## WEST SUSSEX COUNTY COUNCIL CONSULTATION

<b>TO:</b>	Arun District Council FAO: Harry Chalk
<b>FROM:</b>	WSCC – Highways Authority
<b>DATE:</b>	10 April 2025
<b>LOCATION:</b>	86 Ancton Way, Bognor Regis, PO22 6JP
<b>SUBJECT:</b>	M/22/25/PL Demolition and erection of 1 No dwelling. This application is in CIL Zone 4 and is CIL Liable as a new dwelling.
<b>DATE OF SITE VISIT:</b>	n/a
<b>RECOMMENDATION:</b>	Advice

SITE PLAN - PROPOSED

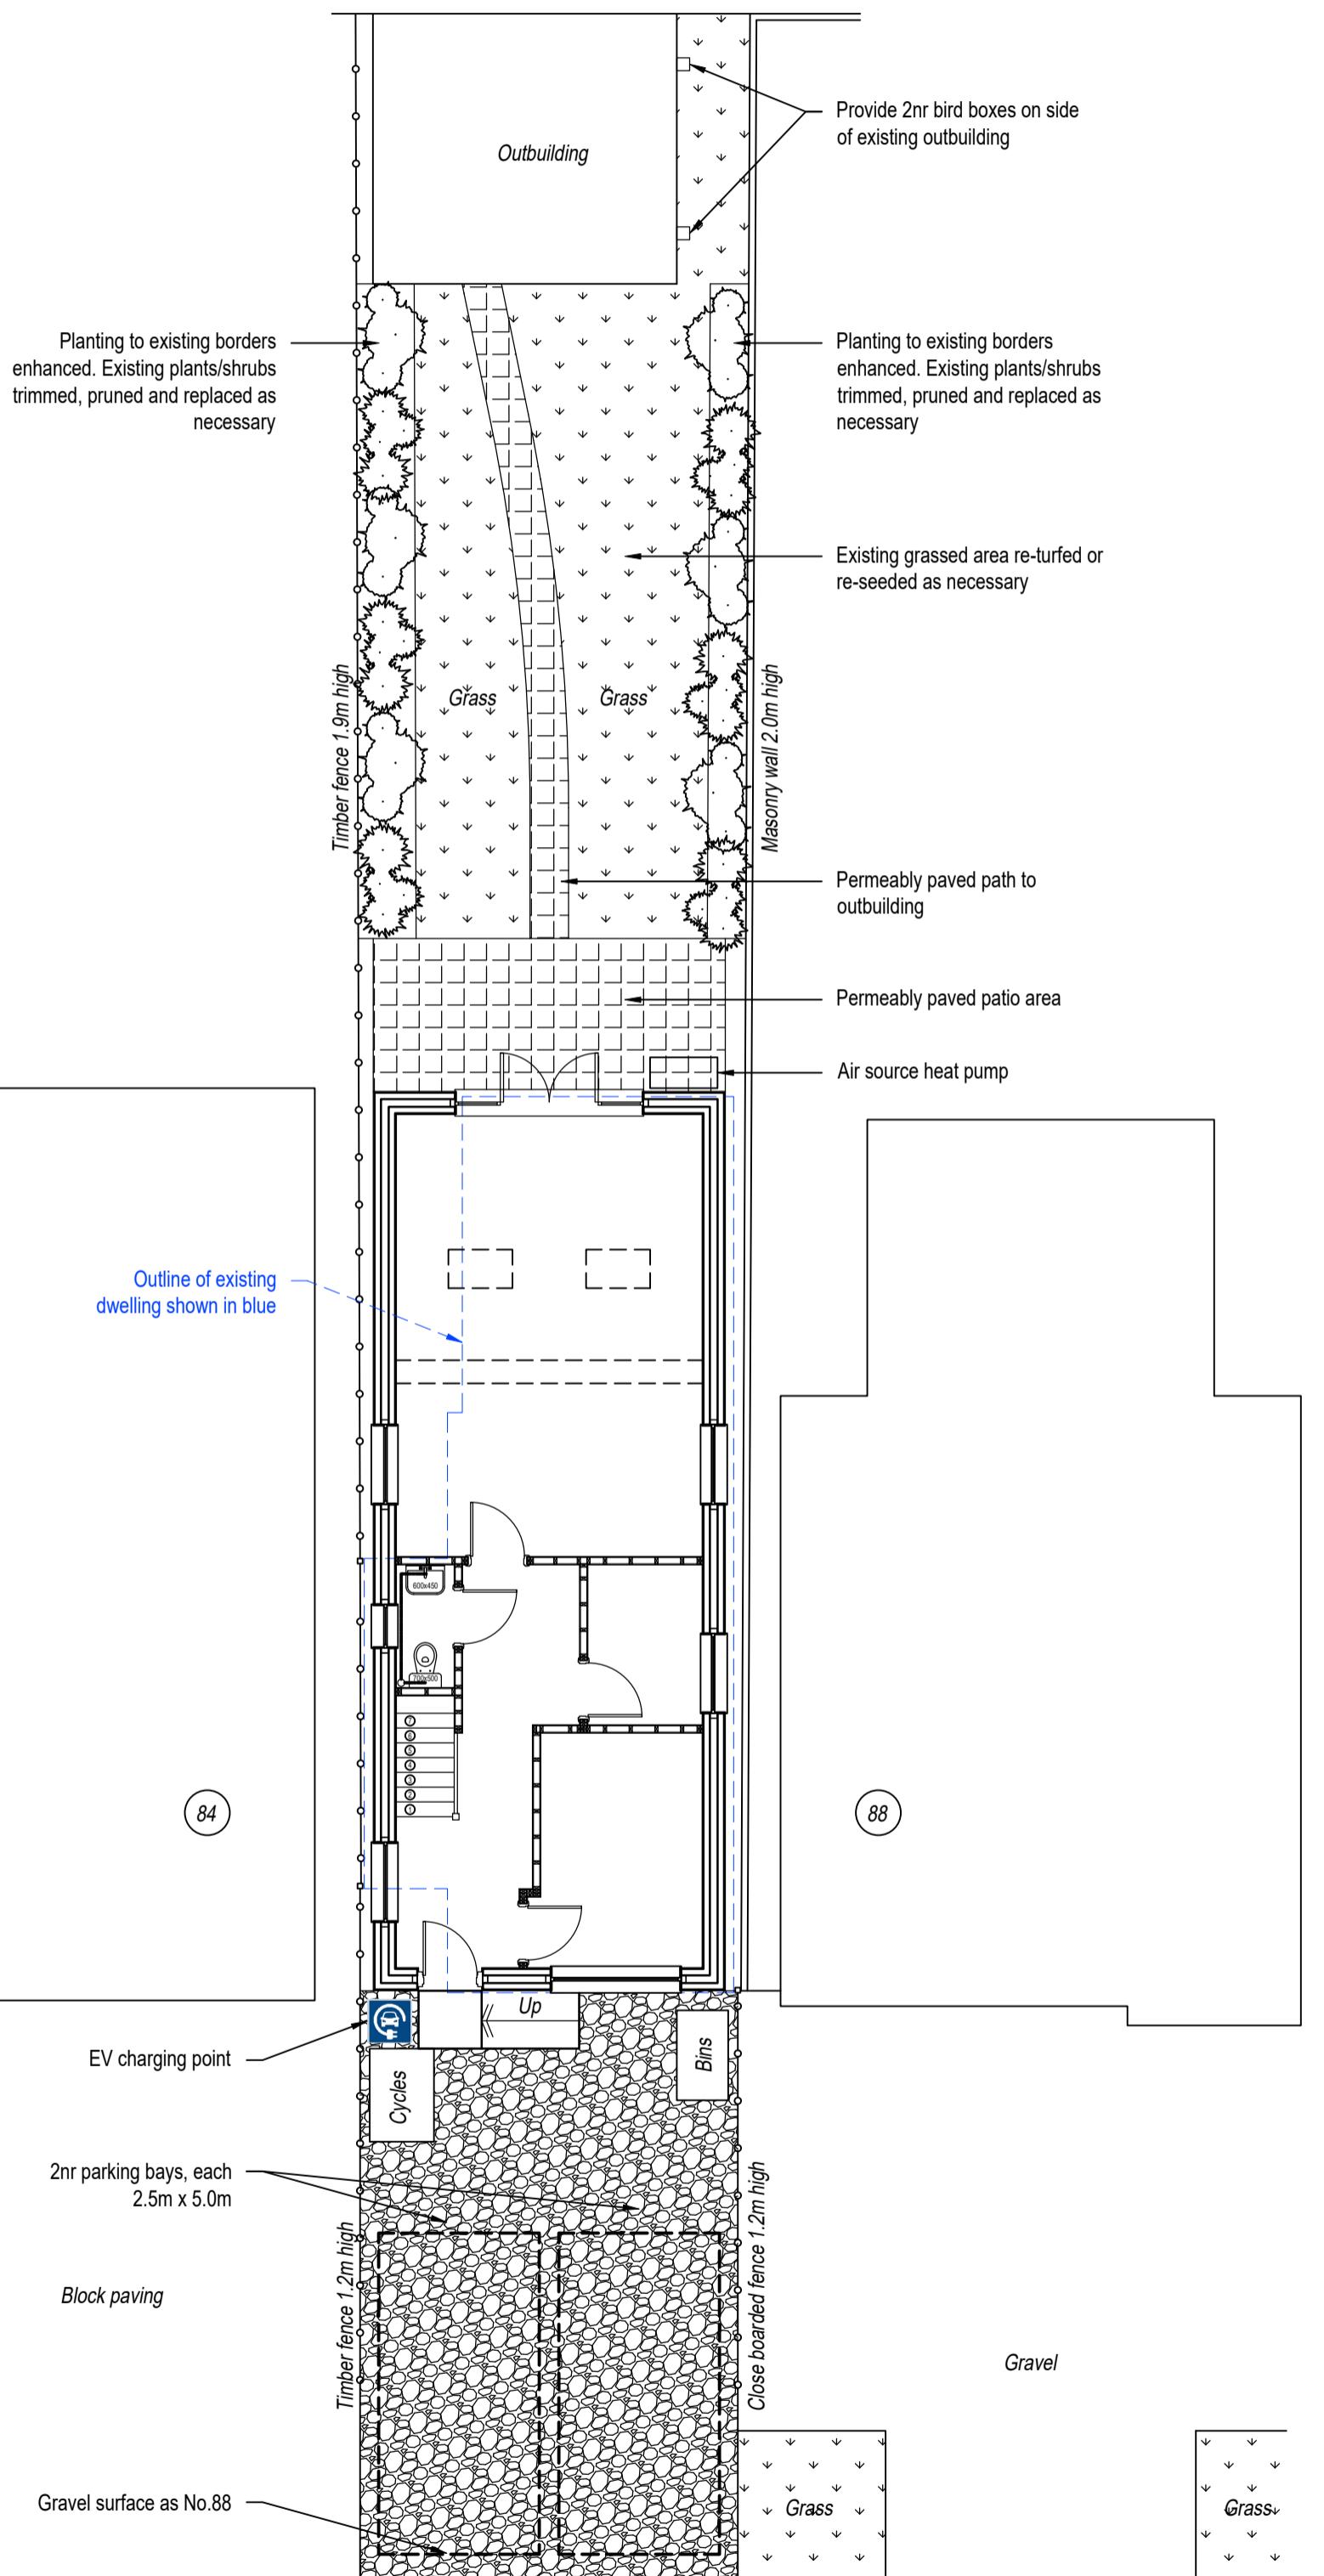
Under Arun Parking Standards (adopted January 2020), the LHA would anticipate that two parking spaces would be sufficient for a dwelling of this size and location. The proposed plans indicate that two parking spaces will be provided for the proposed dwelling. The proposed parking spaces meet the minimum specifications of 2.4 x 4.8m.

On-site turning does not appear achievable, so cars may have to exit the site in a reverse gear. However, this arrangement appears to be operating on site currently and is not anticipated to result in an adverse highway safety impact on the publicly maintained highway.

The proposed plans indicate that secure and covered cycle parking will be provided to promote sustainable travel.

No part of the development shall be first occupied until the car parking has been constructed in accordance with the approved site plan. These spaces shall thereafter be retained at all times for their designated purpose.

No part of the development shall be first occupied until covered and secure cycle parking spaces have been provided in accordance with the approved site plan. These spaces shall thereafter be retained at all times for their designated purpose.
